### **Response to Planning Application**

**Application ref:** AL/121/21/PL

**Description:** Demolition of swimming pool buildings and erection of 1 No. new dwelling using the existing access. This site is in CIL Zone 2 & is CIL Liable as new dwelling.

**Location:** Rear of Green Gables Northfields Lane Westergate PO20 3UH

Site Plan

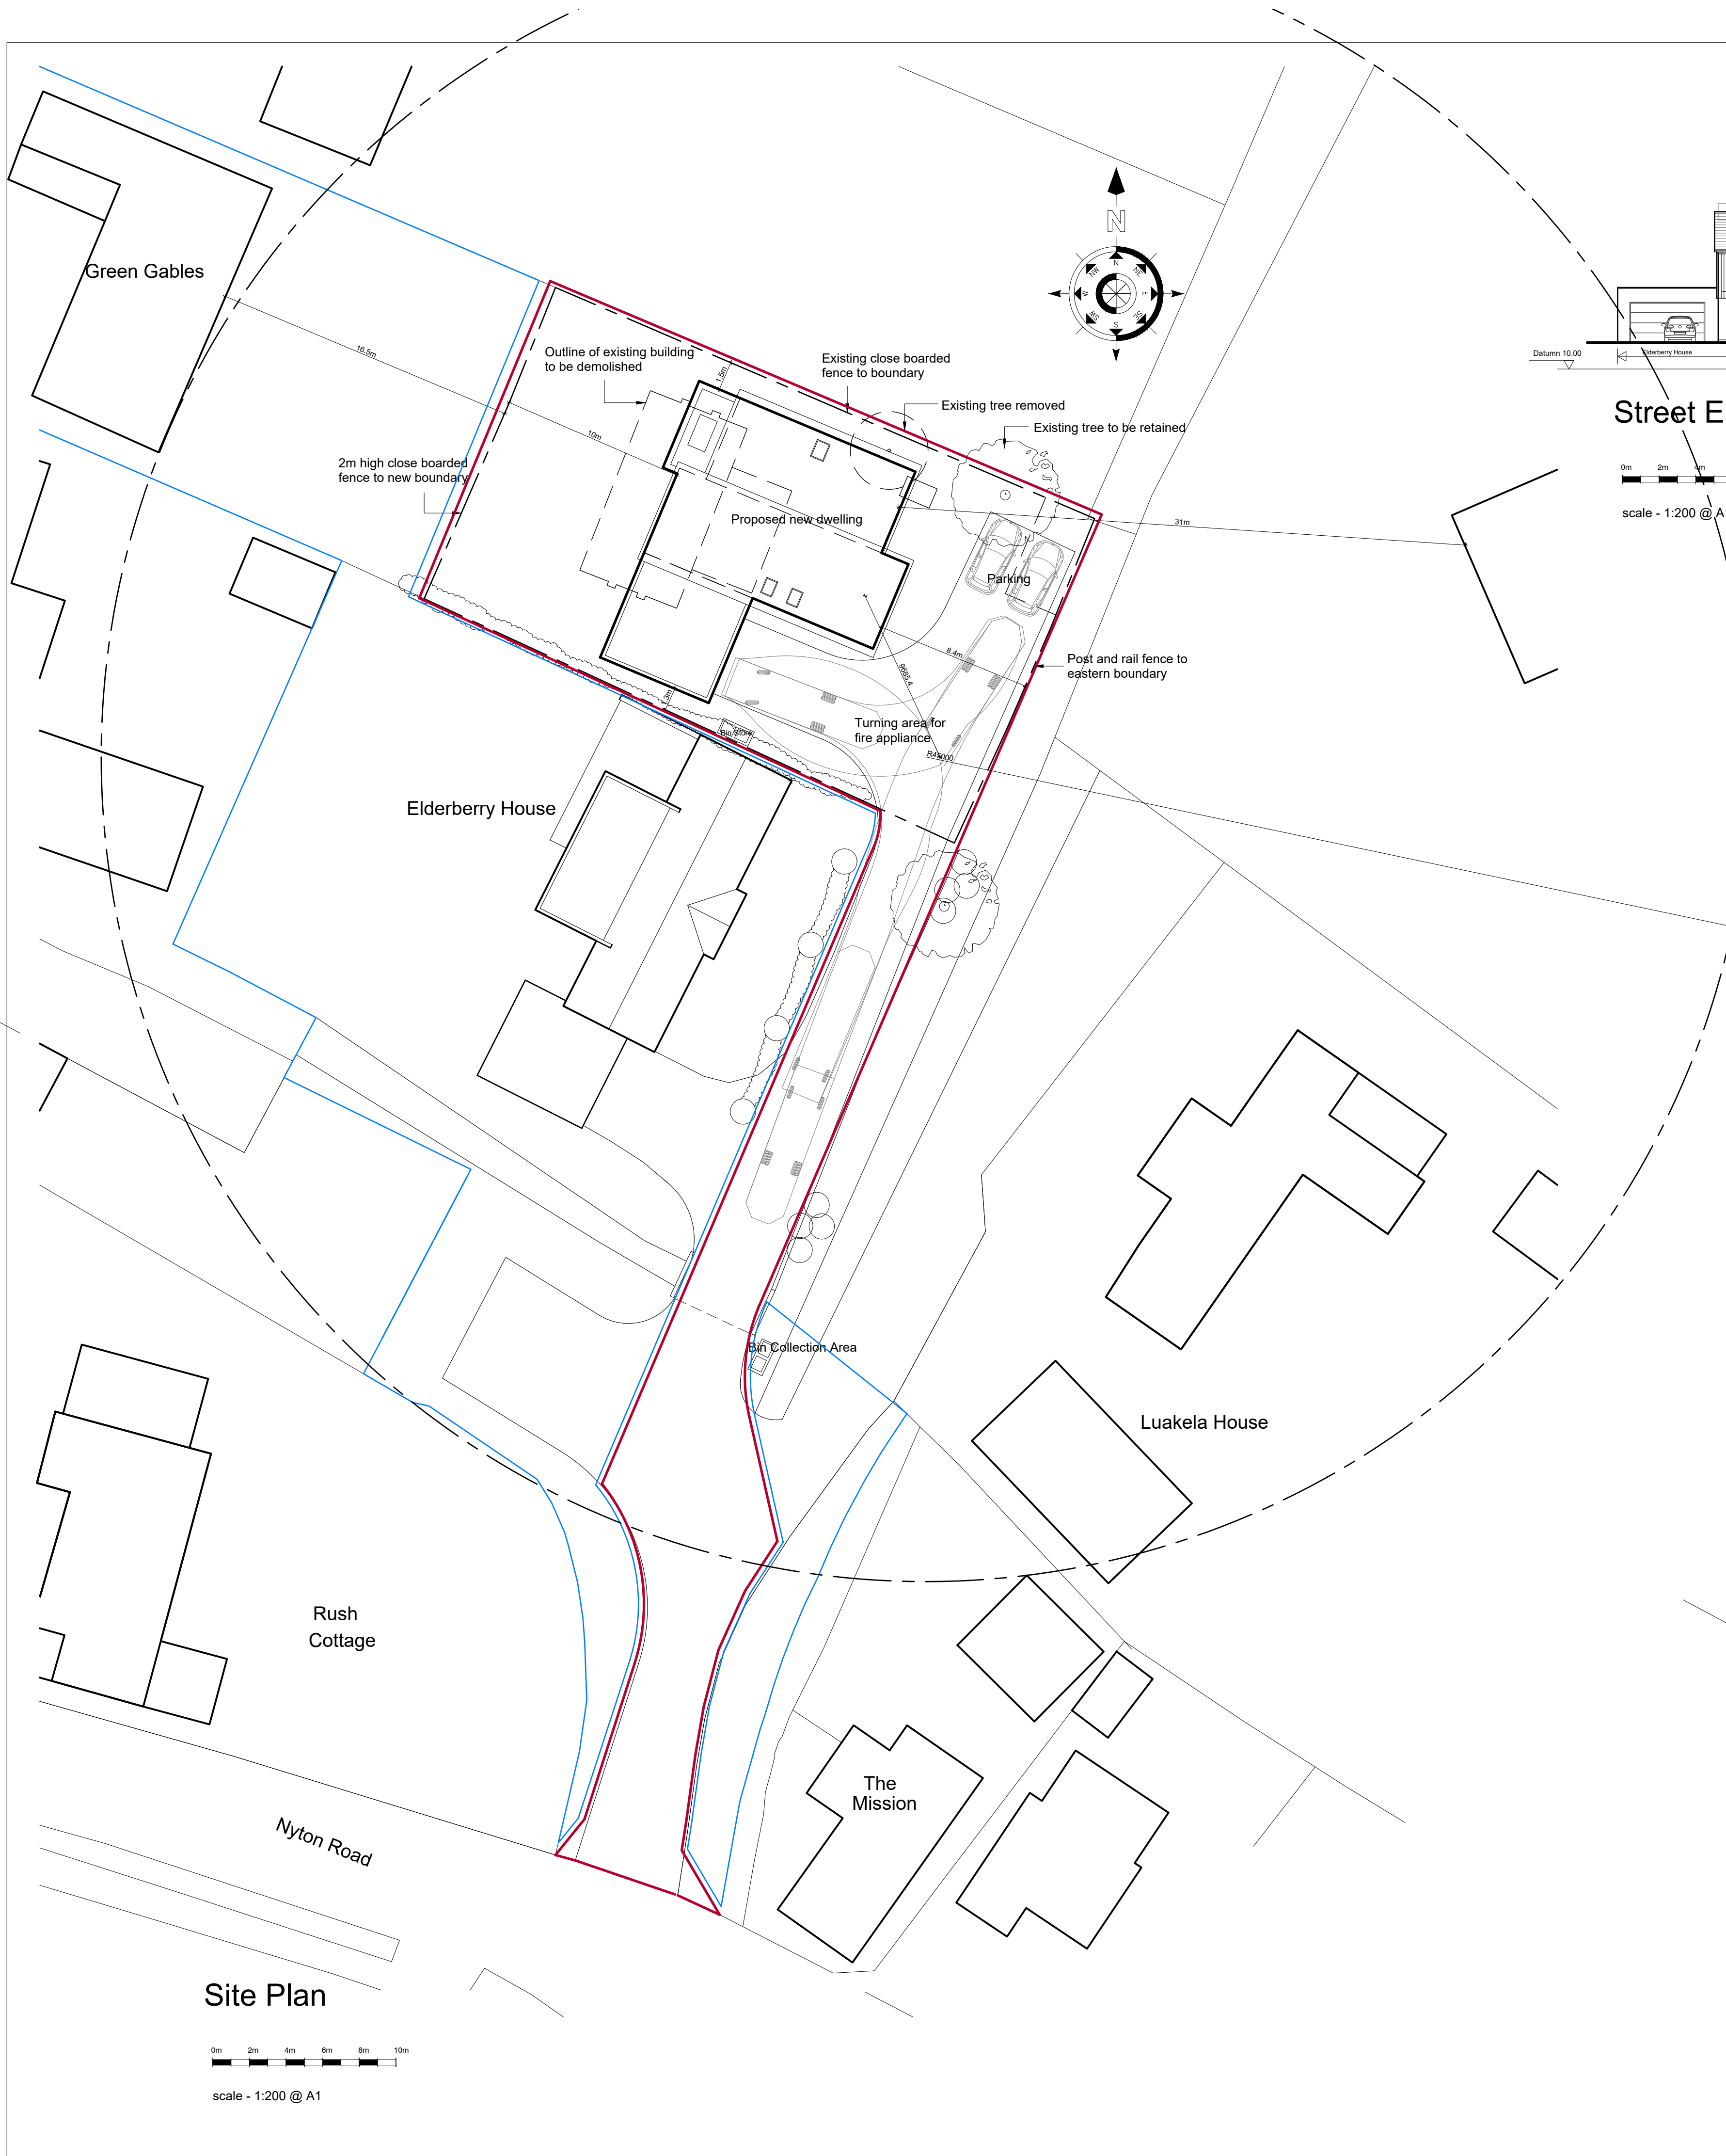
The DAS has confirmed that Ecological Appraisal has been submitted which demonstrates that no further protected species surveys are required. The proposals detail that the hedgerows and existing on site trees are to be retained and protected and will be unaffected by the development.

In line with Policy ENV DM5 of the Arun District Local Plan information on Biodiversity Net Gain will need to be provided. Further information would be required demonstrating what will be included within the scheme and what level of net gain will be created.

The potential impact of the proposals would appear to fit within the surrounds of the neighbouring and adjacent buildings. A landscape proposal would be required to ensure the proposals blend into the surrounding environment in this location. The impact of the proposals on street scene would be negligible because of the site position behind existing dwellings.

A landscape scheme will need to be submitted for approval, this should be plotted in plan and list form and in relation to the trees and vegetation to be retained so that a clear picture of the proposals can be seen. The soft landscape proposals need to detail the quantities, species and size at time of planting and include additional screening as required to strengthen the boundary surrounding the proposals.
